## SM ROCHA, LLC

November 1, 2024

**RE: Flying Horse North Filing 4 / Traffic Generation Analysis  
El Paso County, Colorado**

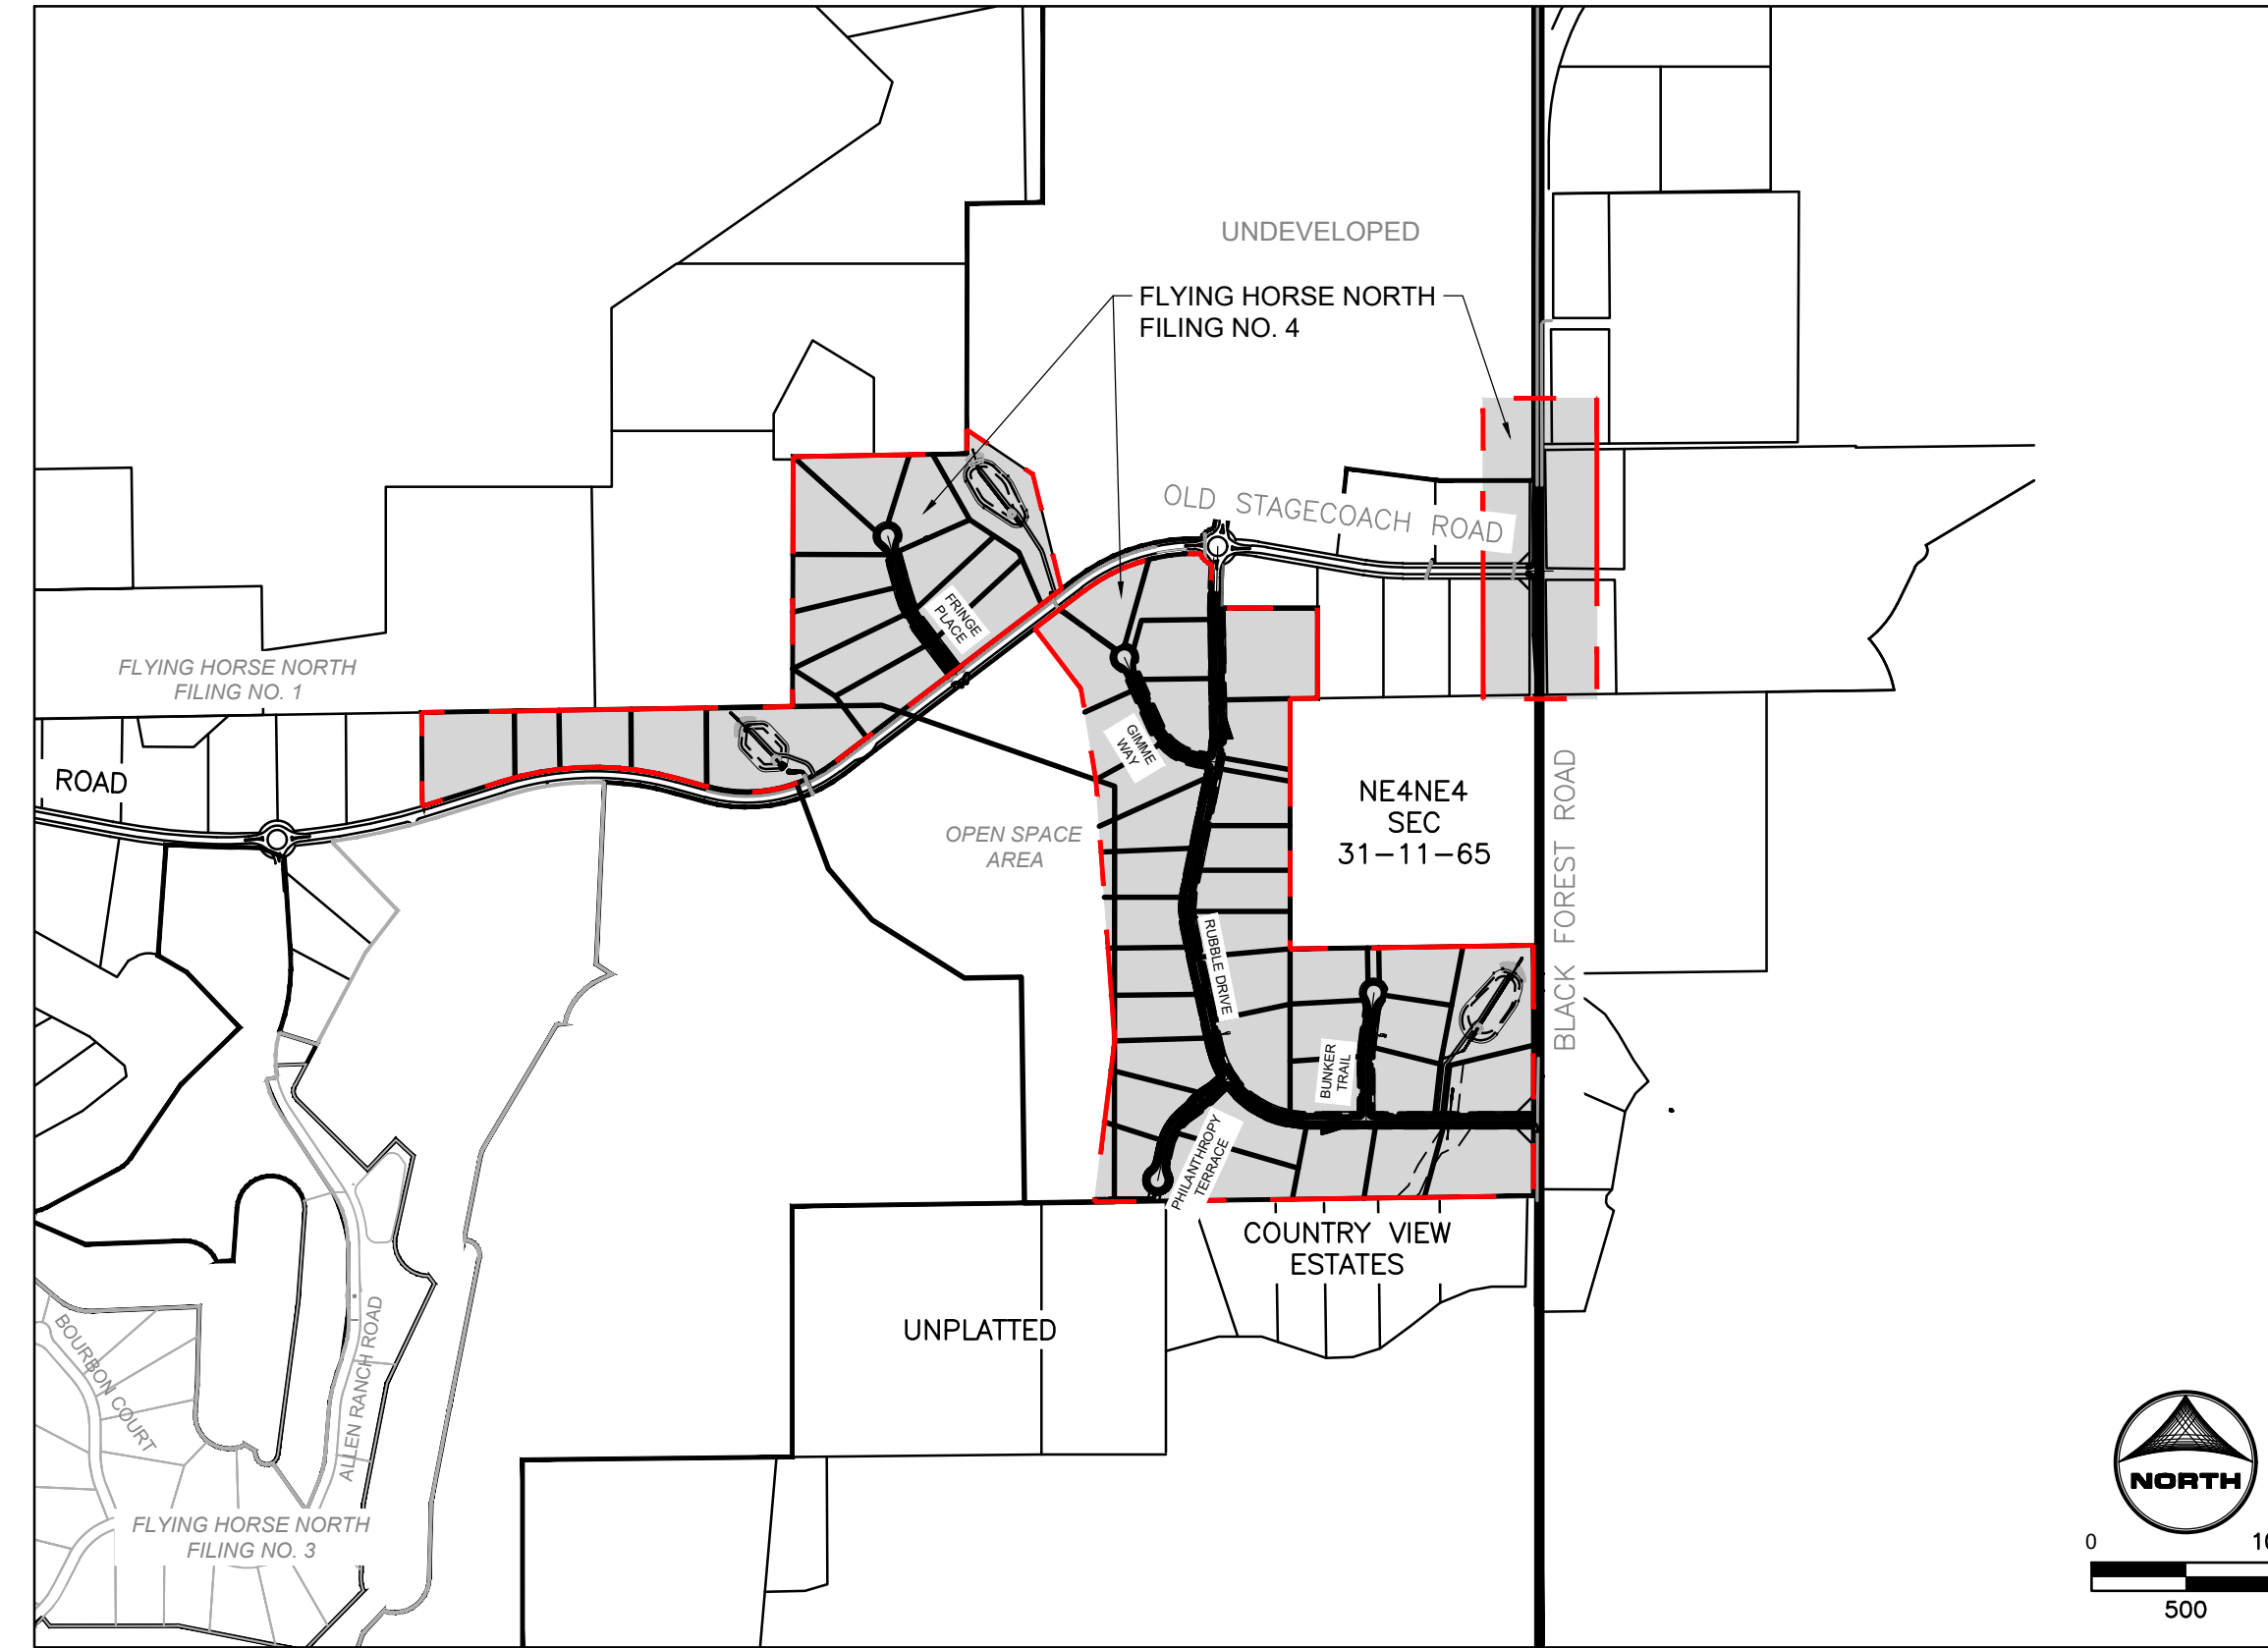
Please include a deviation request for the intersection of Rubble Dr and Black Forest Rd. This intersection does not meet intersection spacing for a minor arterial roadway. It is less than 1/4 mile from the intersection with Terra Ridge Cir to the north. Justification for the location of the intersection may include the acceptance of the location of the intersection within the PUD.
